Marge Schmuckal - Re: 253 Holm Ave -application #2014-00255 - 272-f-012

From: Marge Schmuckal
To: hyrbee@roadrunner.com
Date: 2/11/2014 4:36 PM
Subject: Re: 253 Holm Ave -application #2014-00255 - 272-f-012

Drawing file: 1. Original Plans / C1 Site Plan.pdf

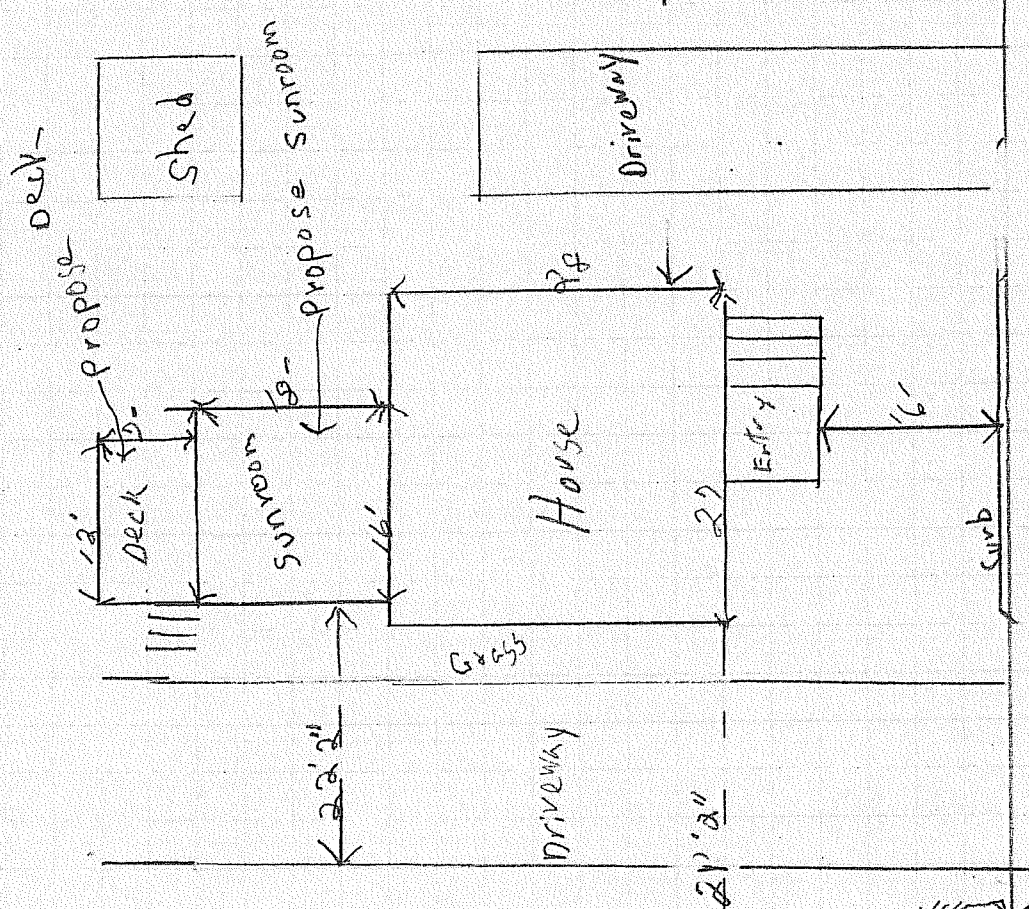
I have been trying to review your application for zoning compliance. Your site plan does not show what the rear setback would be from the deck to the rear property line. I will need a revised plan showing me what that rear setback is. Please revise your site plan so I can finish my zoning compliance review.
